DECISION DELEGATED TO HEAD OF PLANNING

Application No:	H14-1032-21	Applicant:	Executors of P J Borst Deceased c/o G B England Esq
Proposal:	Residential Development - 16 Dwellings - outline approval H14-0912-17		
Location:	Crossgate Lane Pinchbeck Spalding		
Terminal Date:	24th February 2022

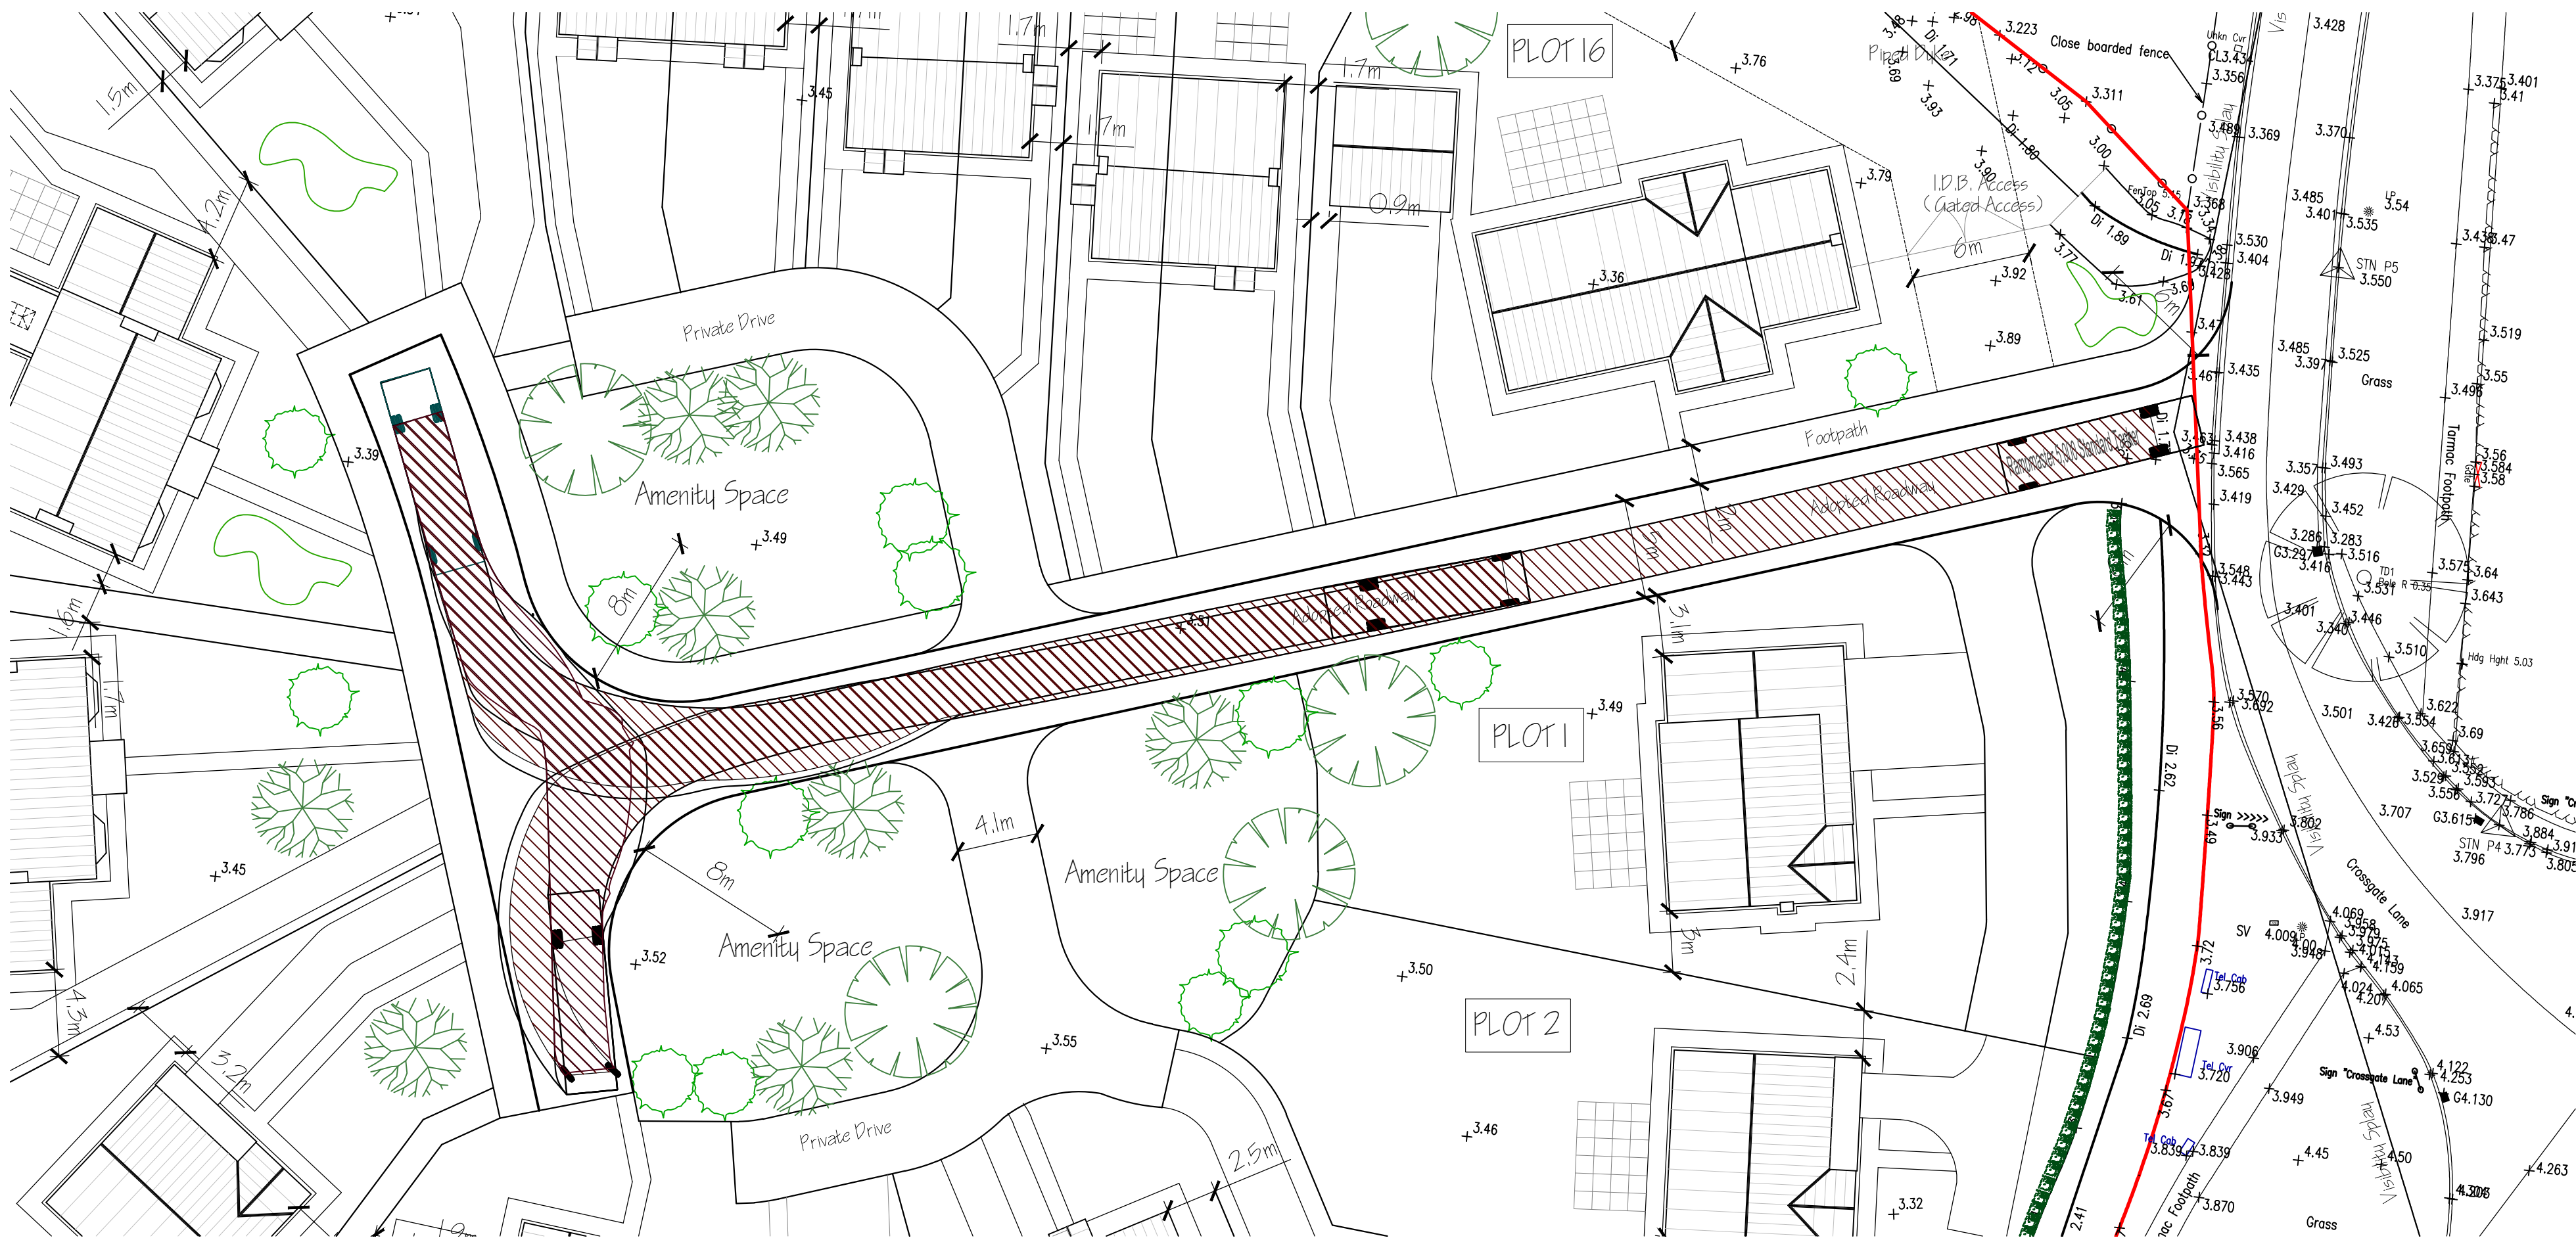
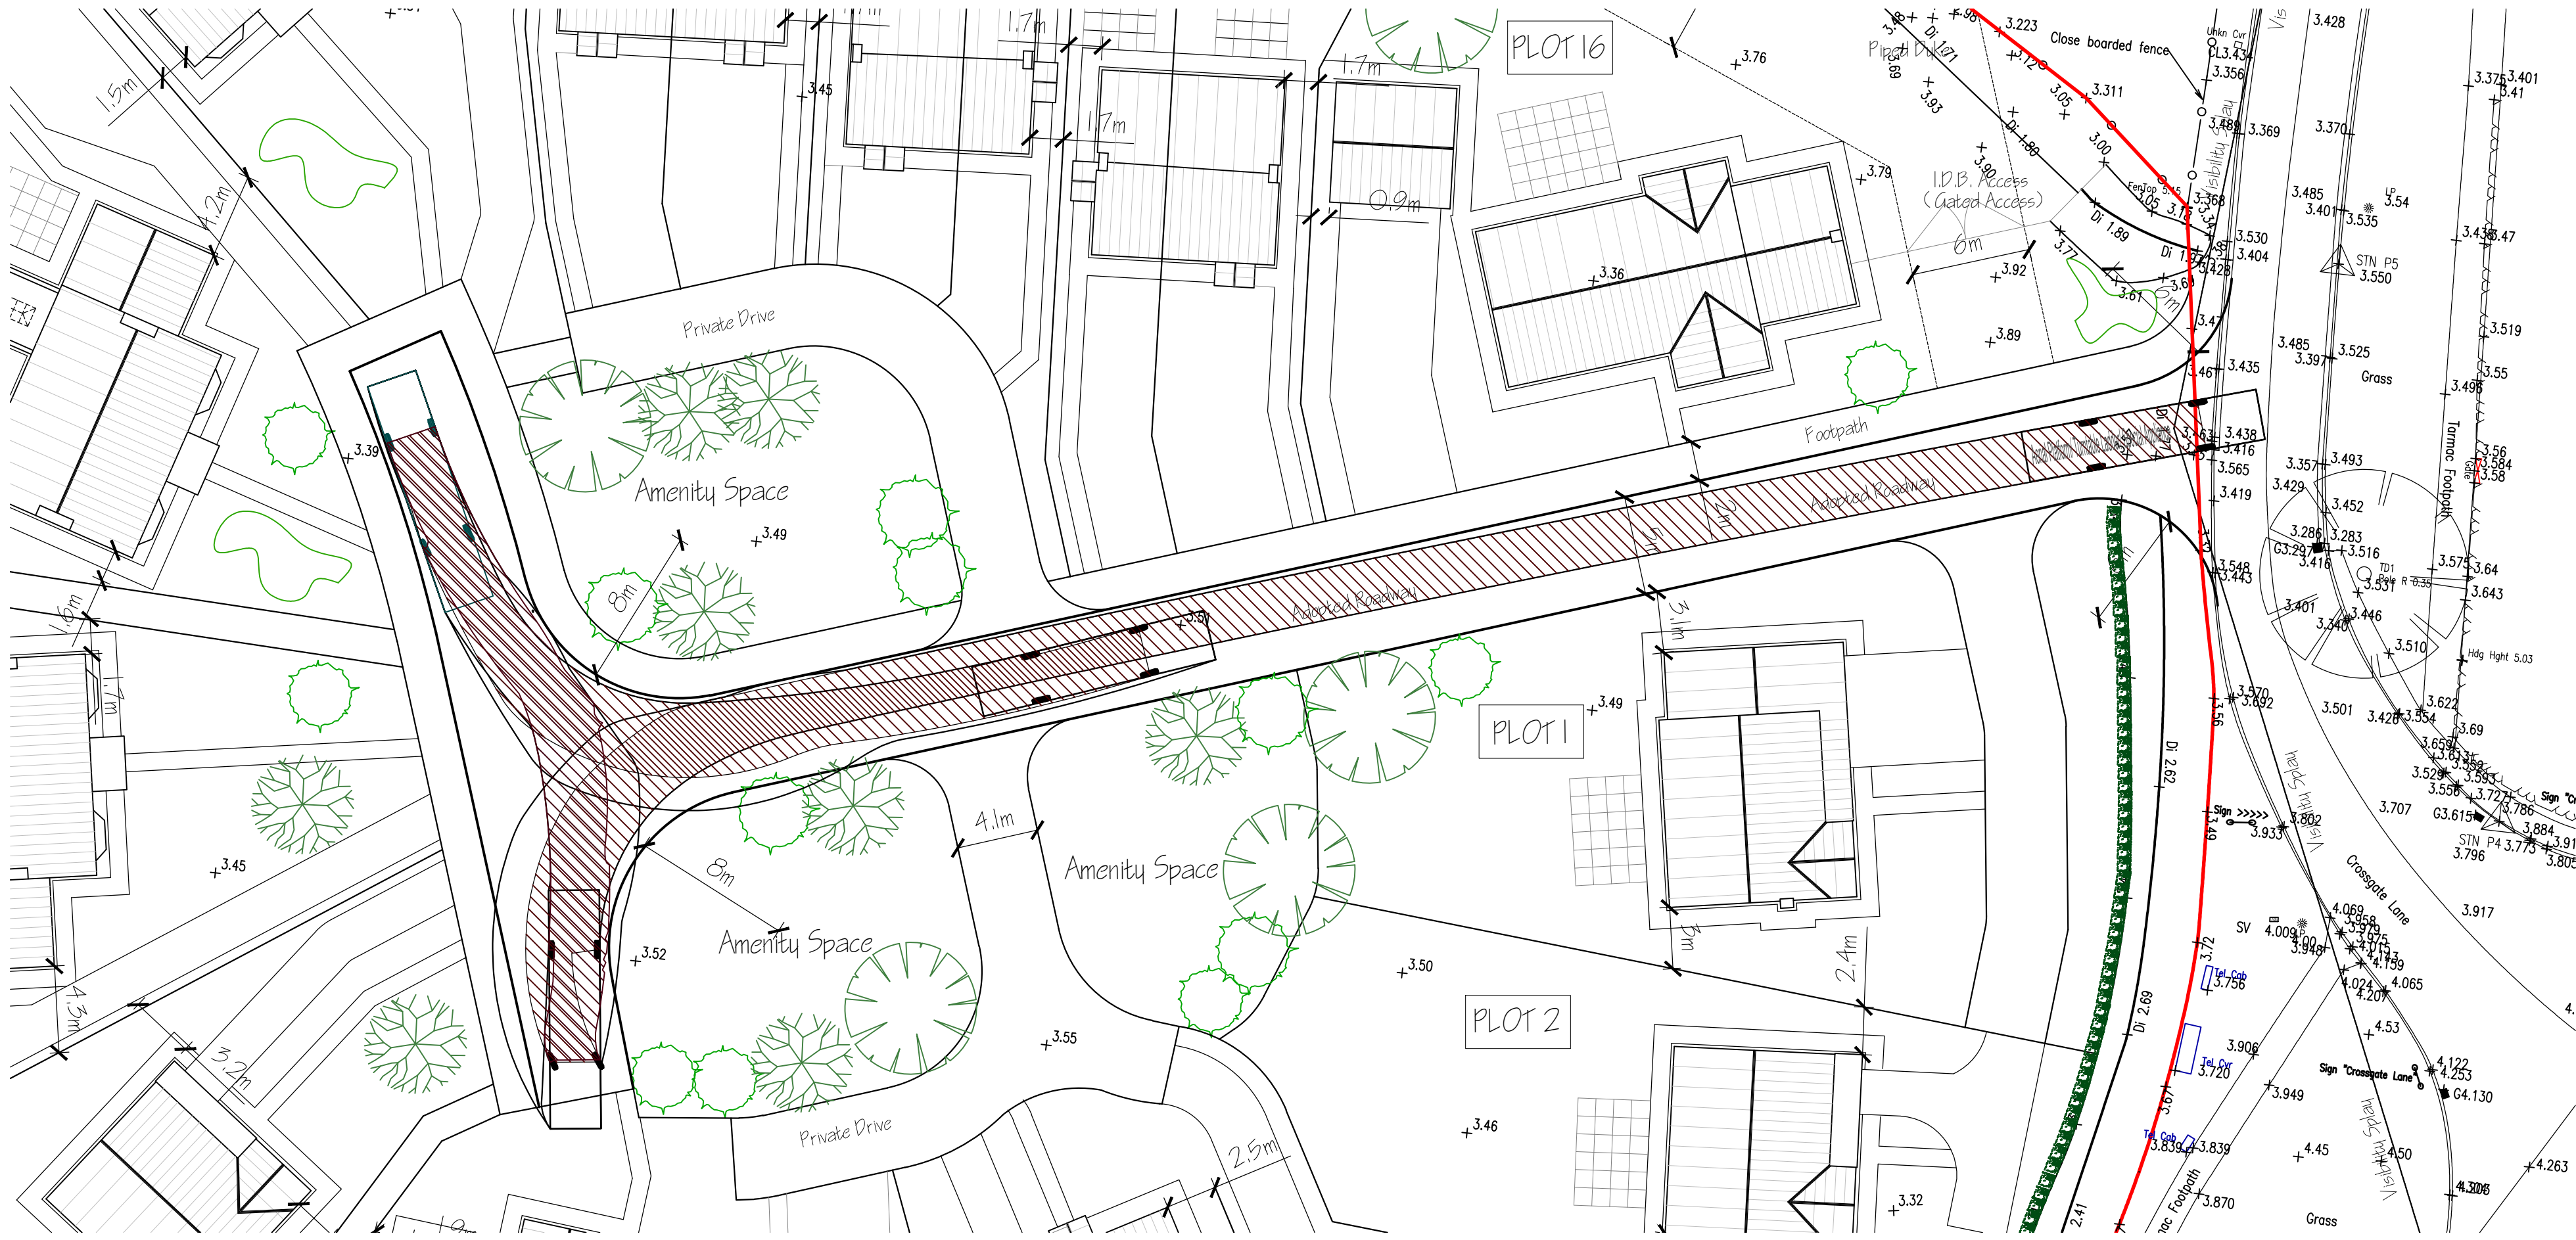
Need clarification on waste collection and private drive is suitable for 18T fire appliance.

The development would be served by public highway, with a limited number of shared drives and everyone can conveniently place their bagged refuse at the curtilage with the public highway. It is considered that the refuse collection arrangements accord with Policies 2 and 3 of the SELLP.
